Rezoning Transportation Analysis

Petition Number: #2022-056

Date	Description
08-24-22	First Review (PDM)

FARM FRESH MARKET
 PARCEL ID: 02756103
 9835 MCKAY RD CHARLOTTE NC 28269
SITE PLAN REZONING 2022-056

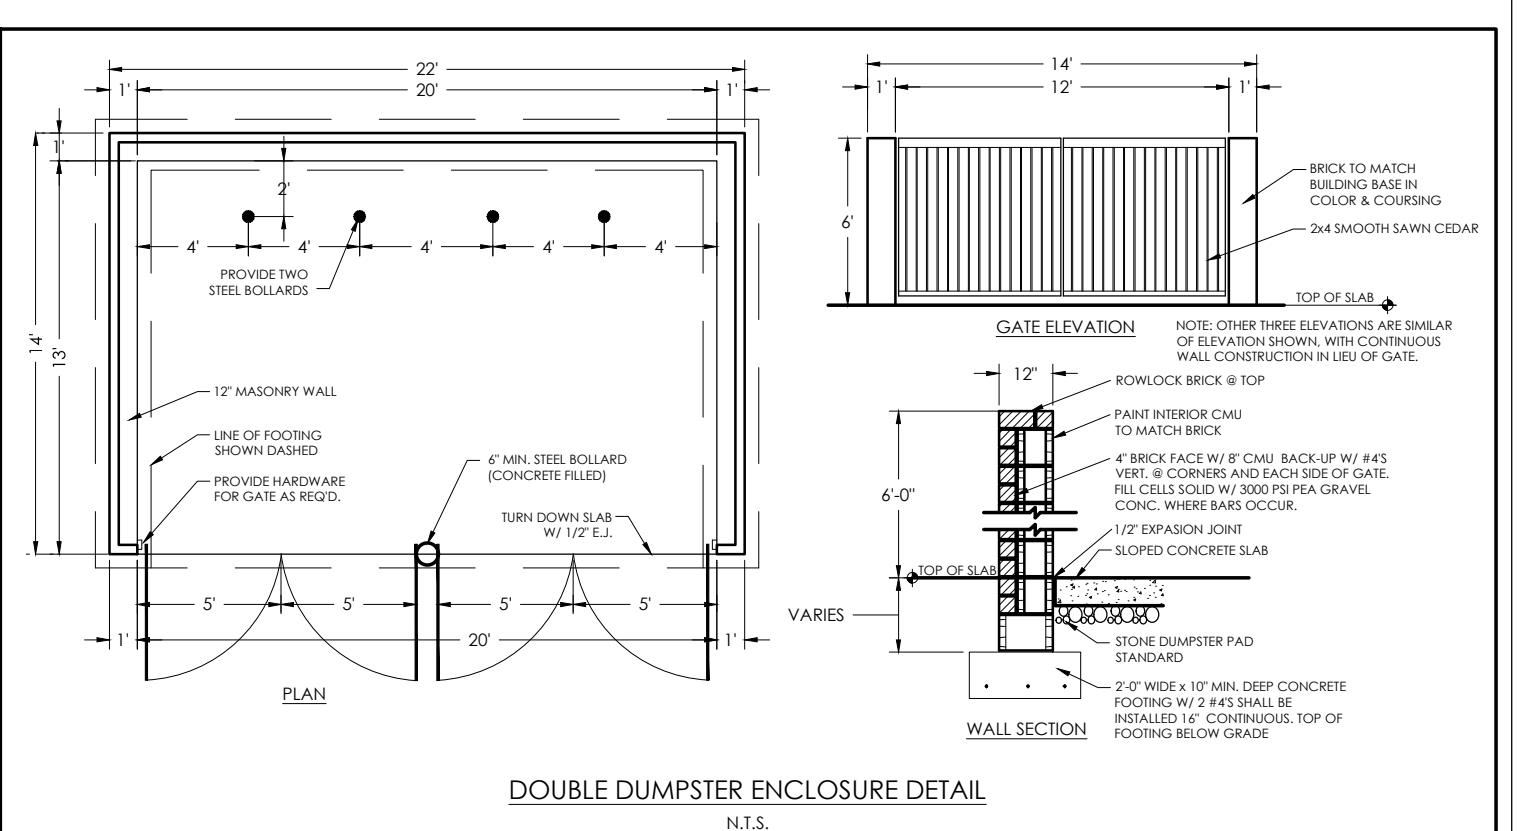
2. Revise site plan to show, callout, and dimension the existing bike lanes, curb and gutter, planting strip, sidewalk, and right-of-way on Benfield Road and Ridge Road.

3. Revise site plan and conditional note(s) to provide a minimum of 57-feet of ROW to be dedicated along the future alignment of Highland Shoppes Drive. The site plan should be revised to not preclude the future extension of the roadway.

4. Revise site plan and conditional note(s) to clarify the proposed site access type at Benfield Road. Revise site plan to extend the existing concrete median on Benfield Road 50-feet north of the proposed driveway.

5. Revise site plan and conditional note(s) to clarify the site access at Brice Knoll Lane. Clearly depict the limits of the existing road. Extend roadway within the existing/proposed ROW with a proposed access aisle with pavement section constructed to the CLDSM U-05 series for commercial wide street. Dimension the proposed ROW for Brice Knoll Lane from the centerline of the roadway.
